KITTTITAS COUNTY COMMUNITY DEVELOPMENT SERVICES

April 10, 2019

RE: VA-19-00002 and SI-19-00002 – Deemed Incomplete and Request for Additional Information

GRAPHIC SCALE

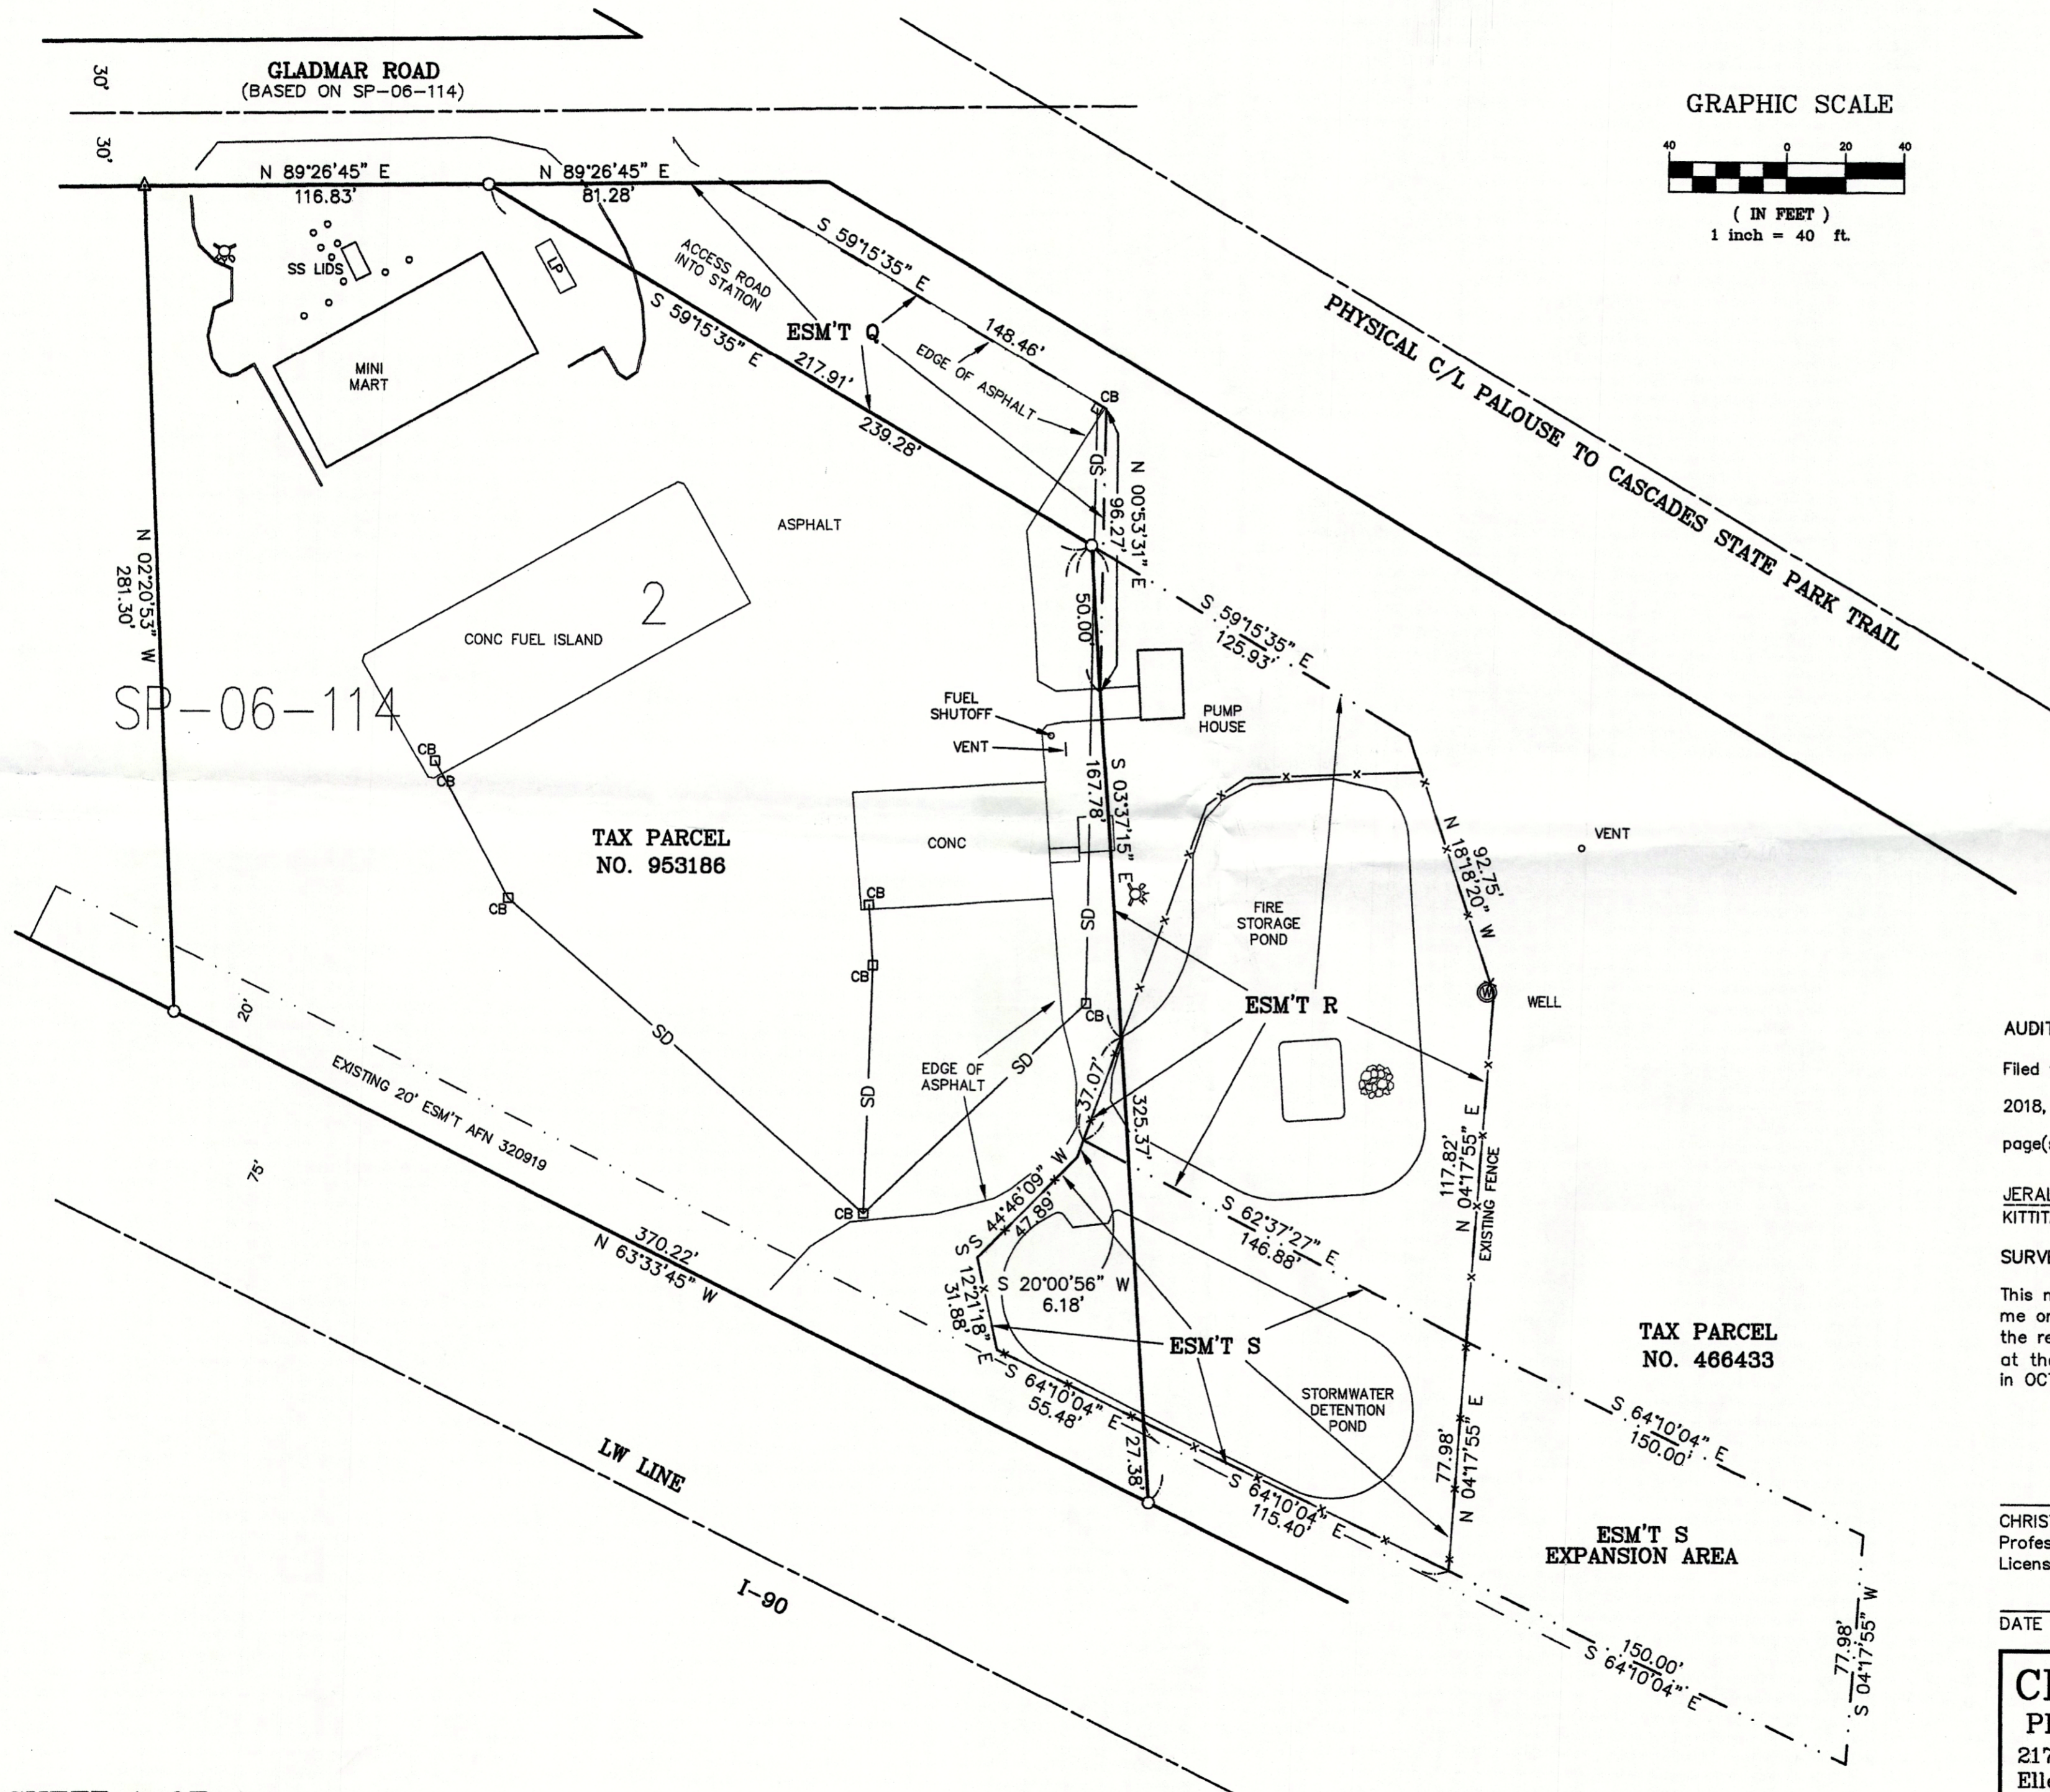
- C) The application does not indicate the likely fall radius of the proposed sign, nor does it show the dimensions from property lines to the sign. In order to continue processing of the application, revisions to the site plan are needed, indicating where the sign is likely to fall in the case of structural failure and collapse, and also show the dimensions from the edge of the sign post to the north, east, and southern property edges; in order to determine whether “*the granting of such variance will not be materially detrimental to the public welfare or injurious to property in the vicinity or district in which the property is located*” as required by item # 3 above.

1. A revised narrative detailing how the application meets the criteria for KCC 17.84.010(1), (2) and (3).
2. Additional information as to plans for the existing sign on the I-90 frontage.
3. A revision to the site plan depicting the likely fall radius in case of structural failure prepared and stamped by an engineer licensed in the State of Washington.
4. A revision to the site plan depicting the dimension from the base of the sign to the north, east, and south property lines.
